Weir Phillips Heritage

Re: State Significant Development Application for the Inner Sydney High School (SSD 7610)

I have been asked by the Department of Education to address a number of heritage issues raised in the following letters prepared in response to the above submission:

FJMT have amended the SSD plans in response to the submissions received. The following takes into account the amendments made. The following should be read in conjunction with the revised HIS dated September 2017. Issues raised with regard to archaeology are addressed by others.

Section C 1:200
1:200

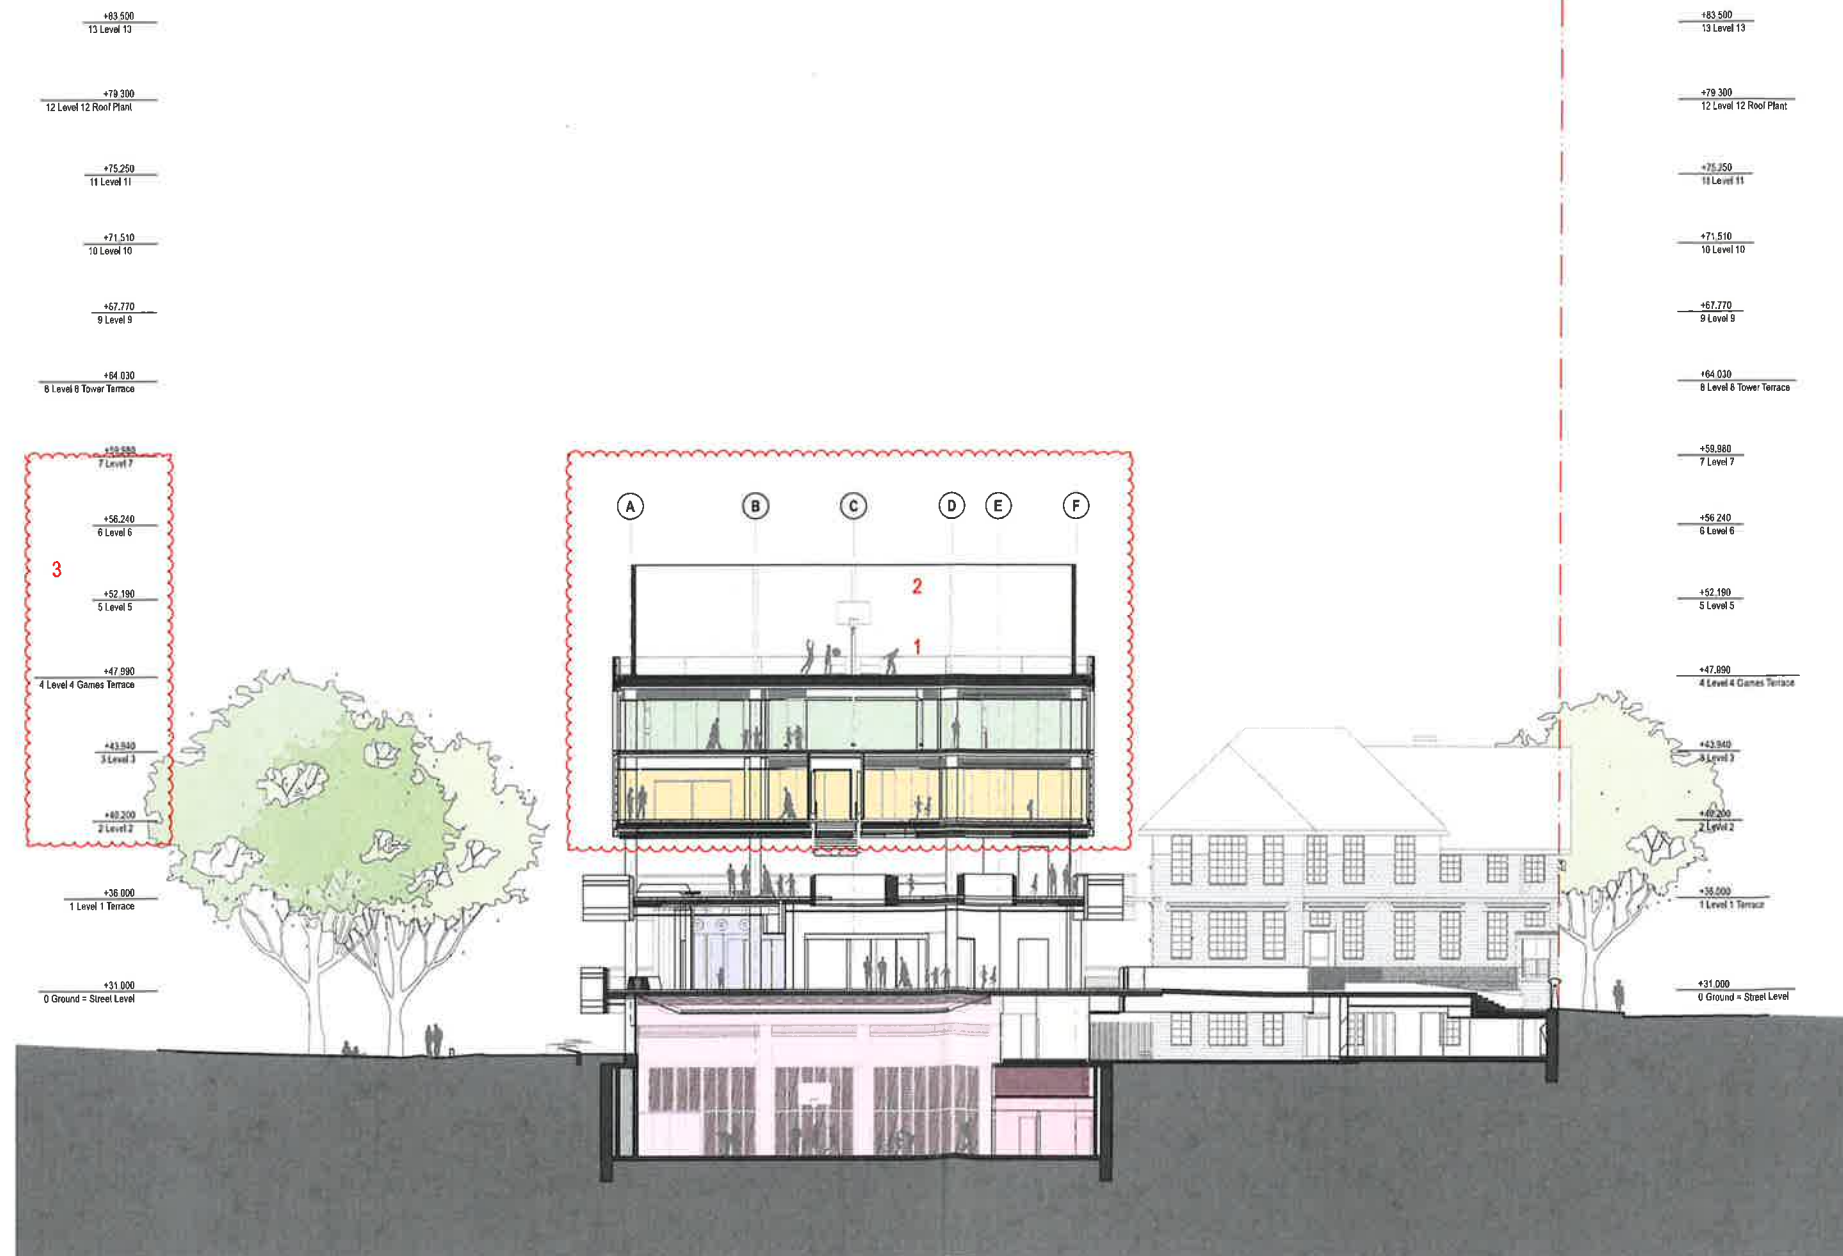
‘A slender and simpler form of the tower, along with a decrease of the storeys at the podium, would reduce its visual impact to the setting of the park. While the proposed variations of external finishes on the tower and podium help in breaking up their scale, they also create complexity in appearance and a possible visual clutter. The complex form of the building overall may be considered to have certain detracting from the landscaping setting in the vicinity and the simple and solid built environment at the distance.’

- The number of studio levels have been reduced from three to two, reducing the bulk and scale of the lower part of the building.
- The ‘twist’ of the tower has been removed, making it appear slenderer, particularly from the north and south. It is noted that the tower proposed by FJMT was the slenderest tower form of the participating schemes.
